**From:** [REDACTED]  
**To:** [Hinckley SRFI](#)  
**Subject:** Hinckley National Rail Freight Interchange response by IP 20040233  
**Date:** 07 February 2025 10:04:58

[REDACTED]  
RE: HNRFI - TR050007

Comments on the additional information supplied by the Applicant, Tritax Symmetry Hinckley, in response to the Secretary of State's "Minded to Refuse" letter of 10th September 2024 by Diana Harrold and David Harrold. IP number 20040233.

**Sapcote Enhanced Scheme
Appendix C (part 5)
Vehicle Tracking Sheet 1**

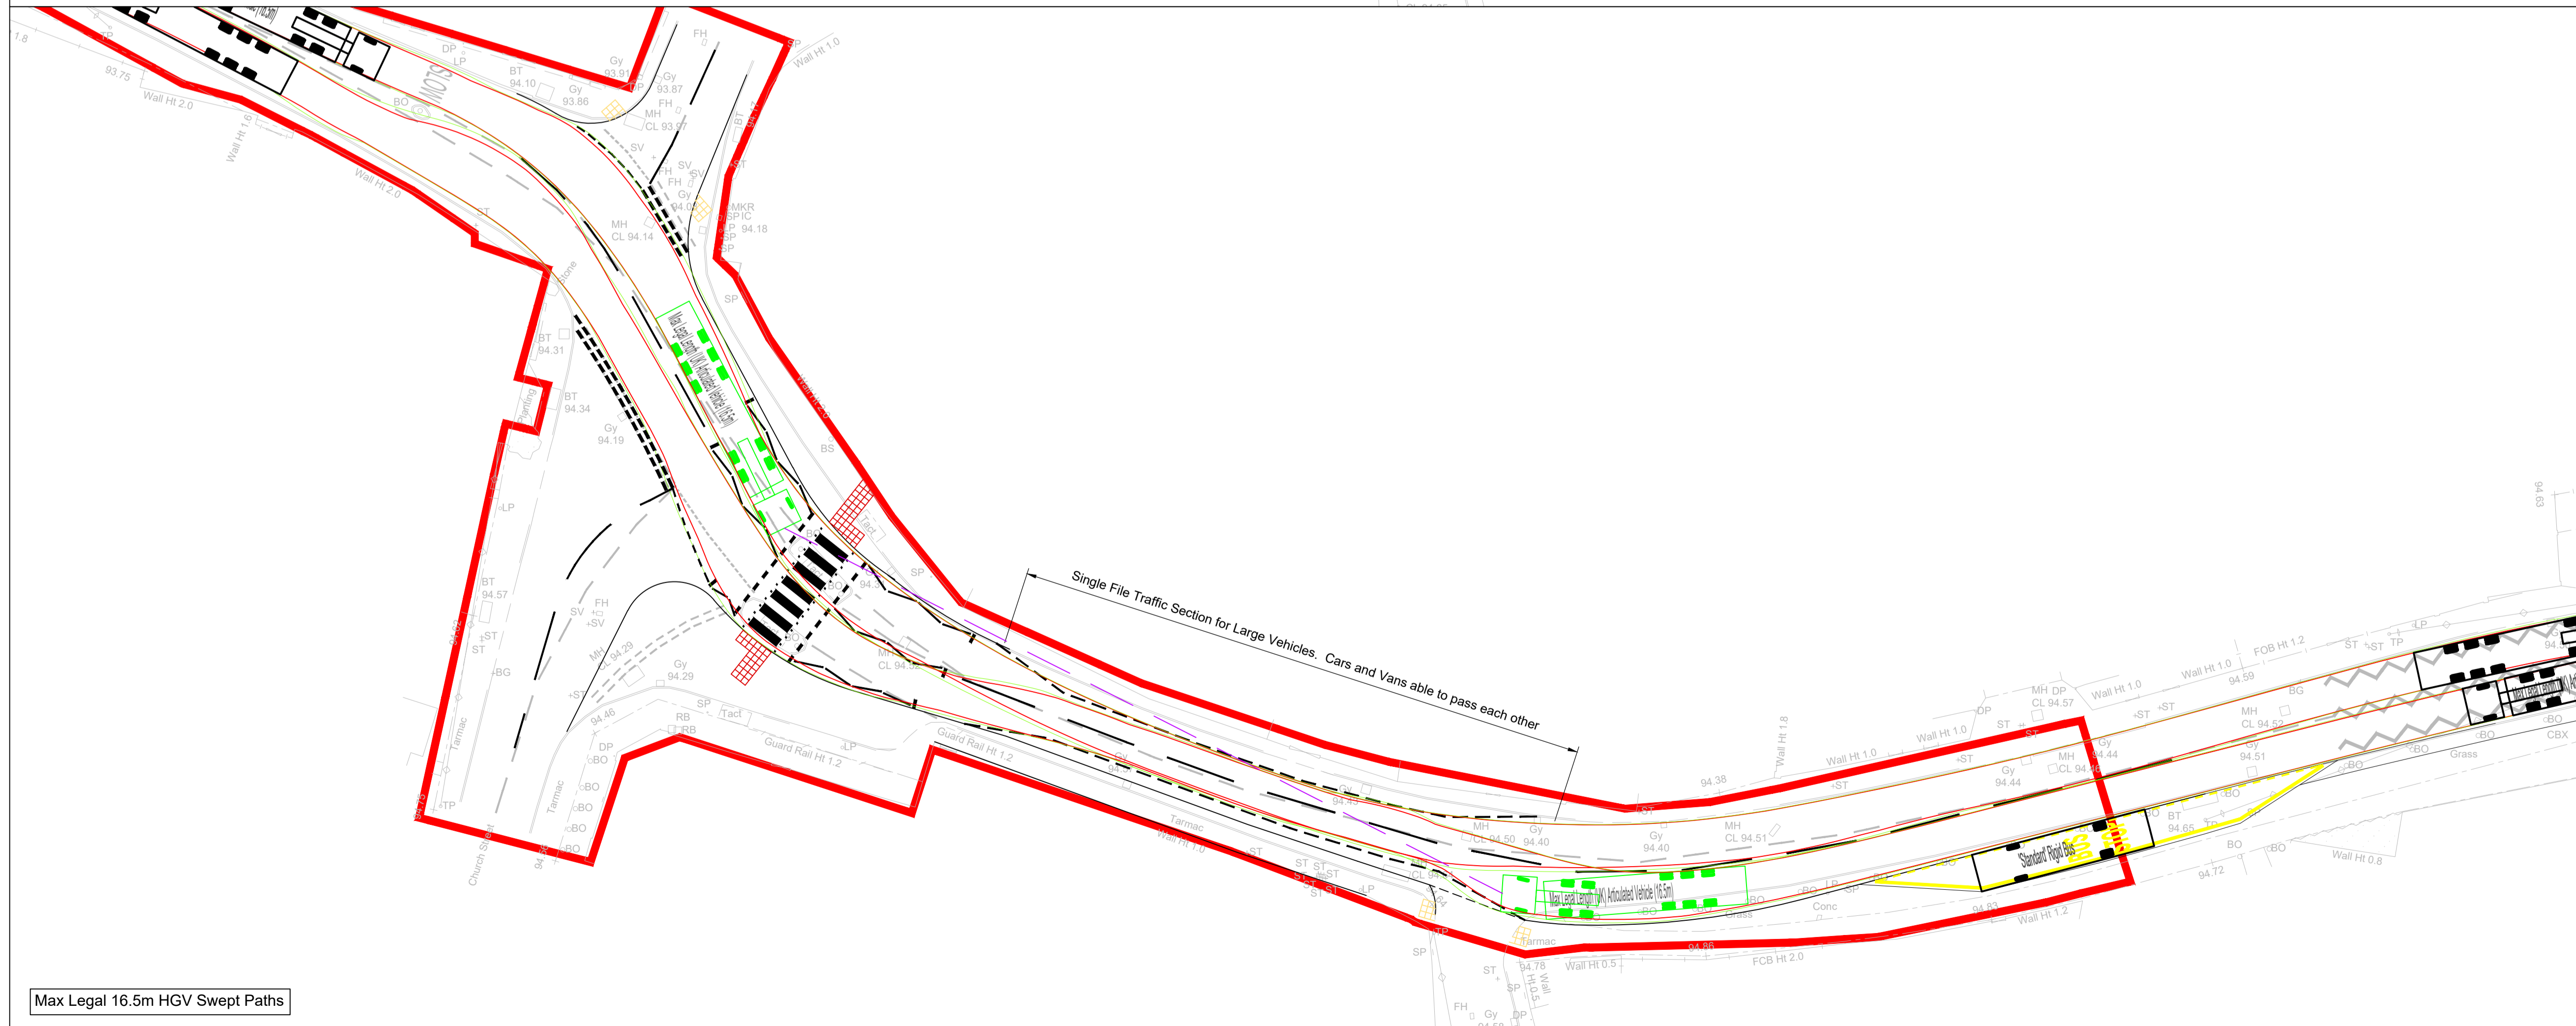
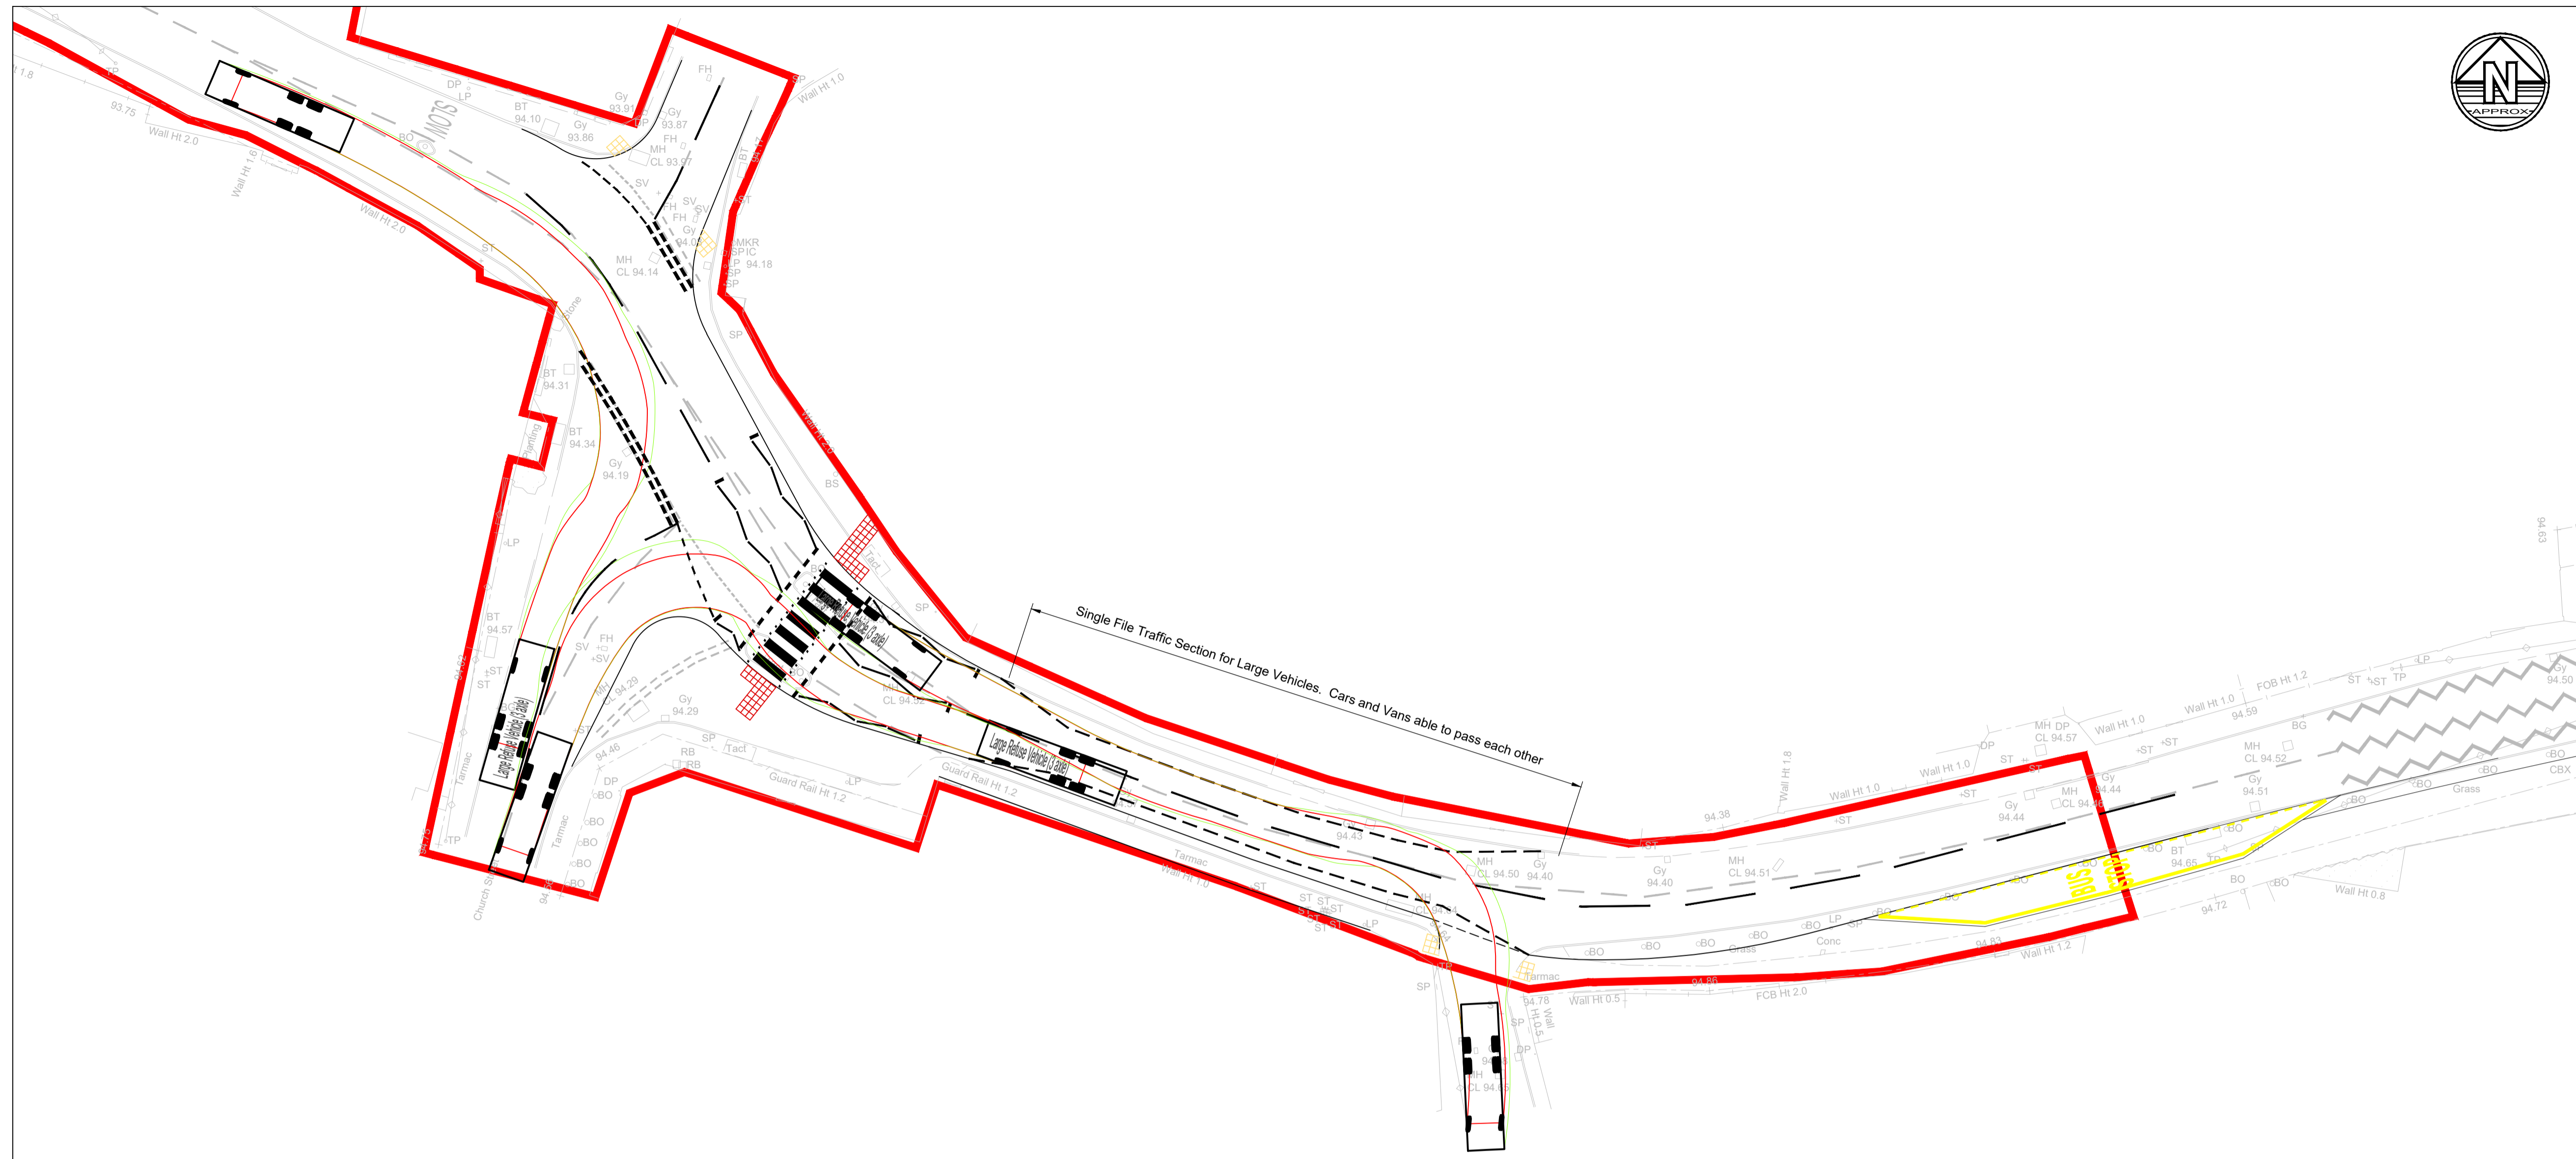
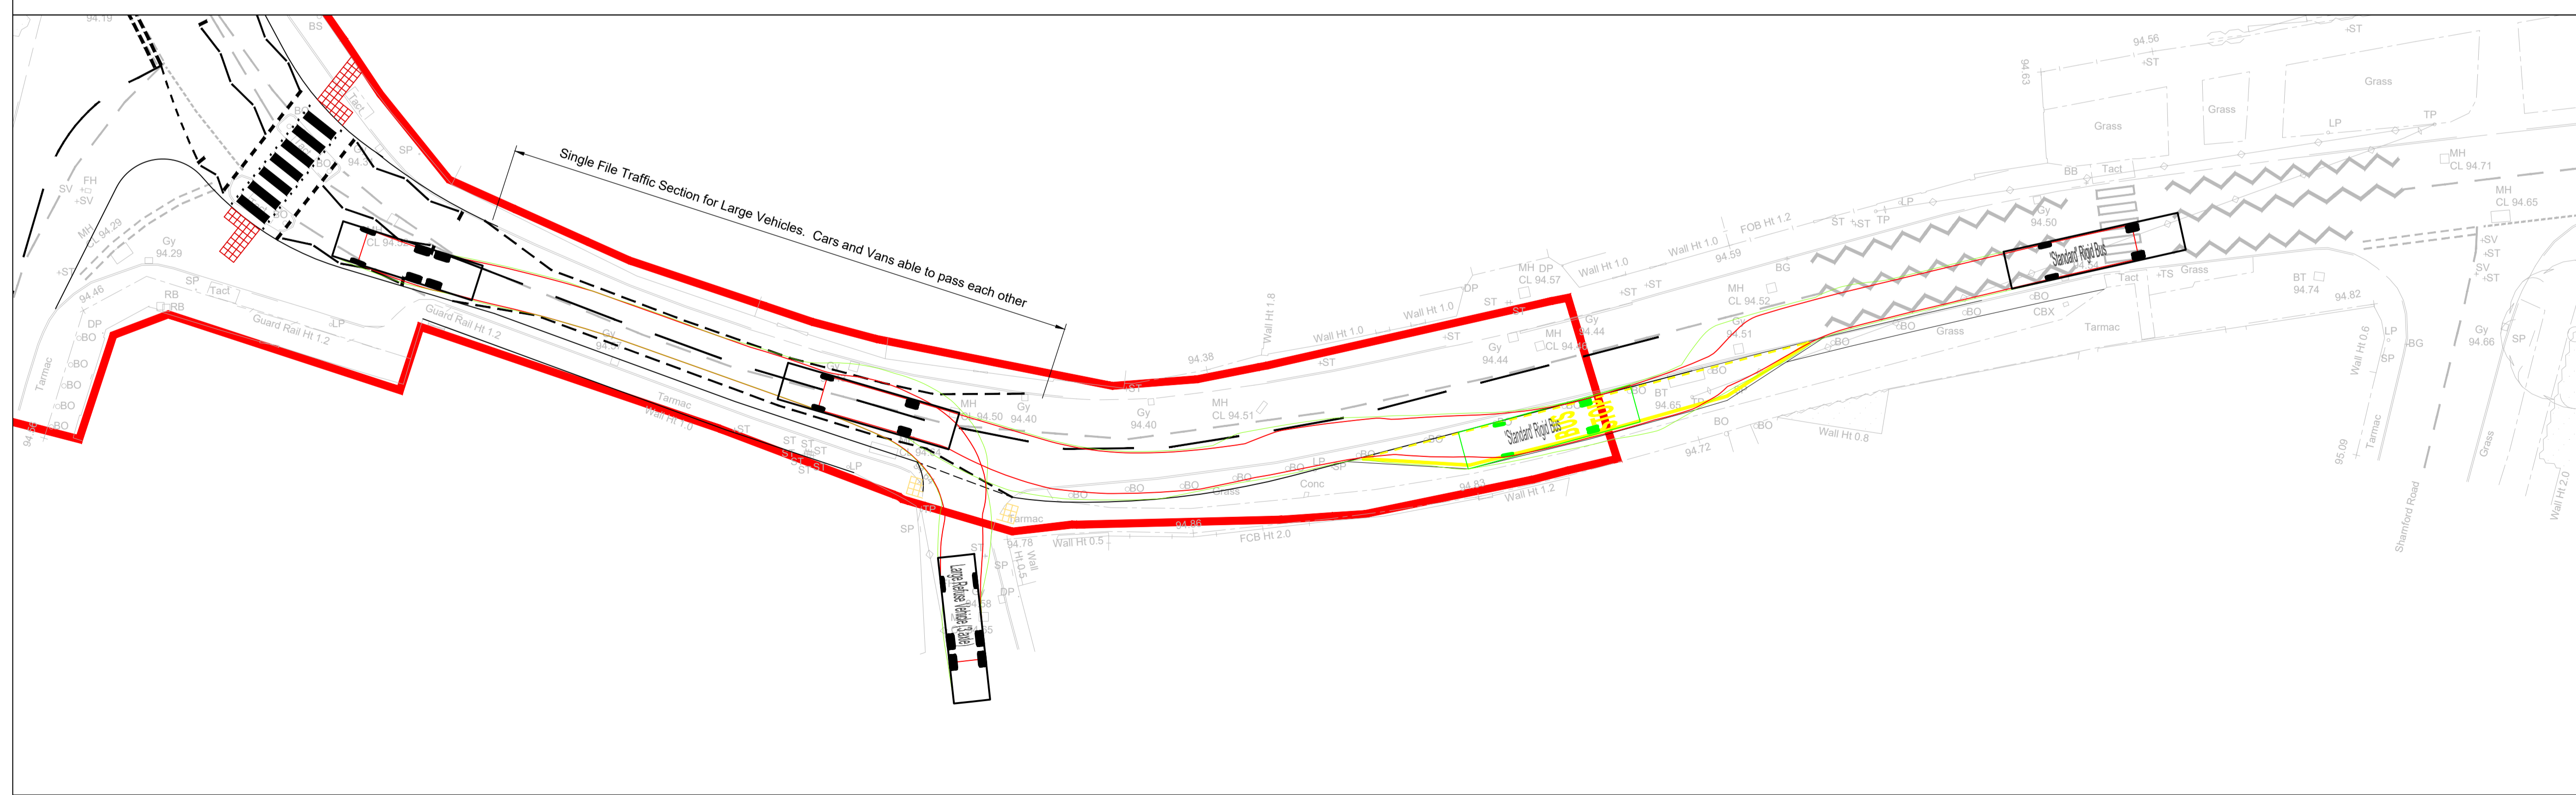
The enhanced scheme in Appendix 2 (C) introduces a section where HGVs are encouraged to take the centre of the road, with added signage to indicate that this is (or might be) happening. However light vehicles can pass in either direction. From normal driving experience, these schemes work in cases where visibility is quite good (e.g. an arched bridge on a straight road) but in this case, along with many distractions, distance of visibility will not be good. A light vehicle could quite easily encounter a vehicle coming the opposite direction in the centre of the road which would cause many problems. If not a collision, then vehicles needing to reverse into an already difficult junction could be envisaged. This idea of a central area for HGVs will also certainly cause more queues in both directions, of which queues back past the Co-op will make that junction particularly unsafe for pedestrians and motorists. This scheme is badly thought through and will lead to more safety problems.
